NSW Ambulance

**Sutherland Hospital Operating Theatre Upgrade (SSD-11099584)
Request for additional information**

LANDSCAPE PLAN - CANOPY COVER

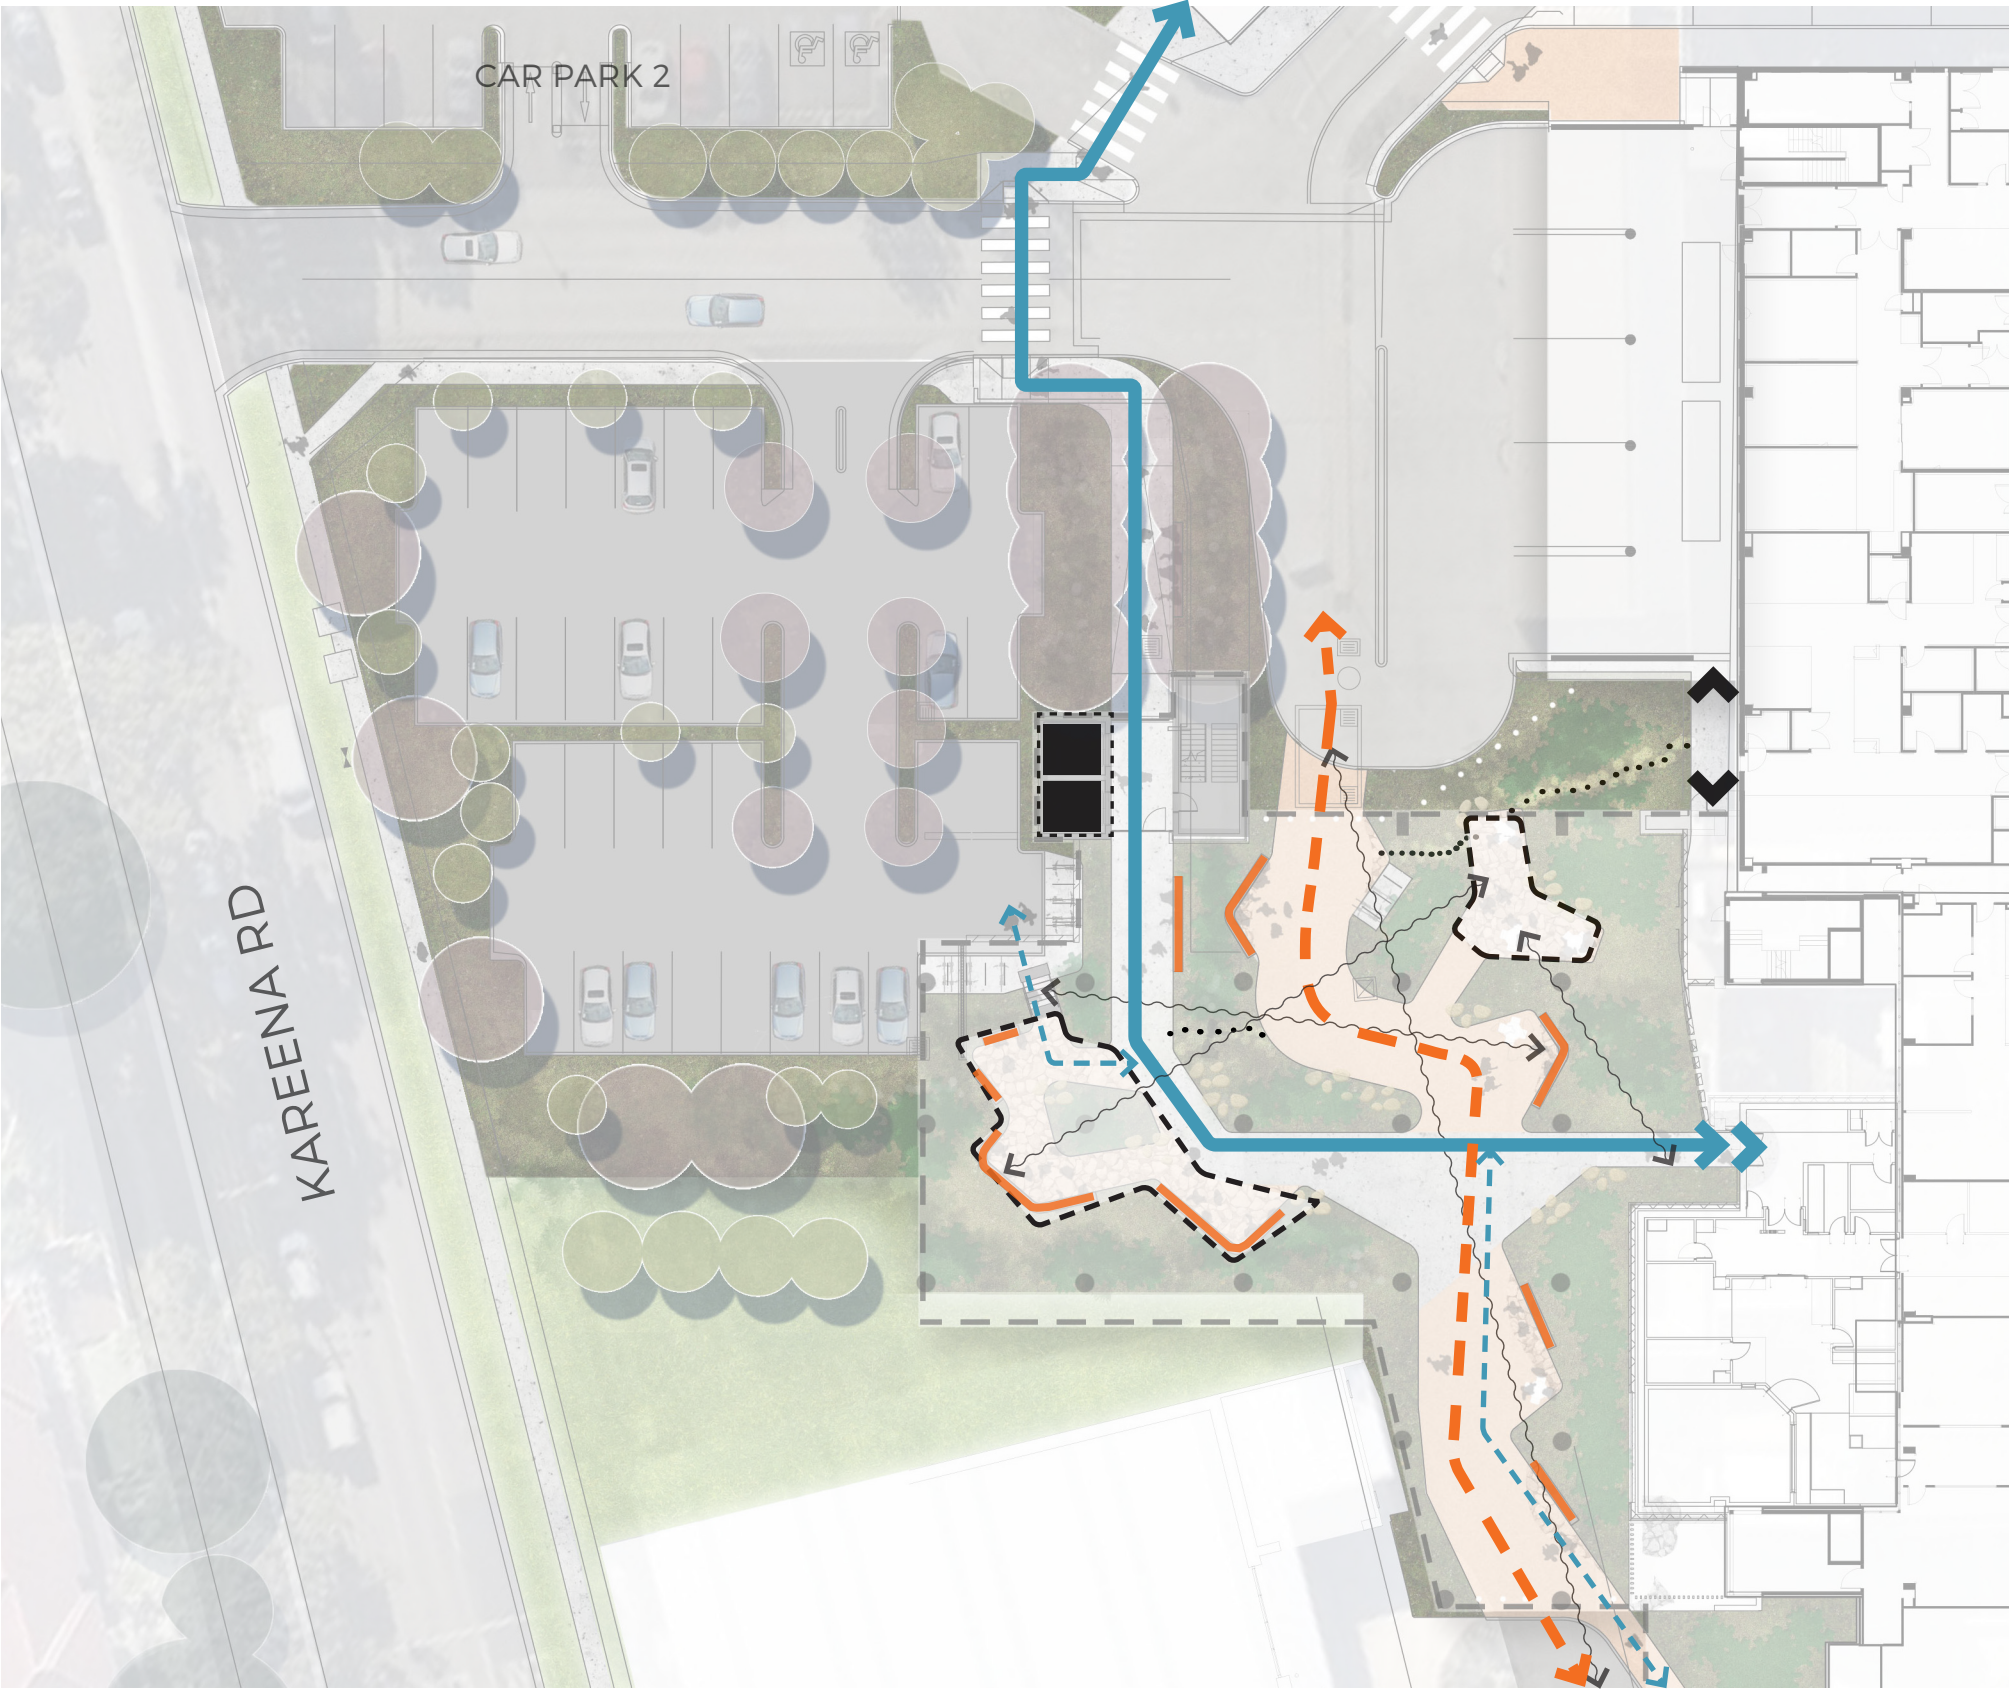
The requested incorporation of 4 street trees on Kareena road adversely effects lines of sight for ambulances exiting the Ambulance Station onto Kareena Road South bound lane with tree trunks and canopies obstructing the view of oncoming traffic. I have reviewed with our Safety and Recovery Business Partner Sam Stack and see supports our objection to the trees being planted.
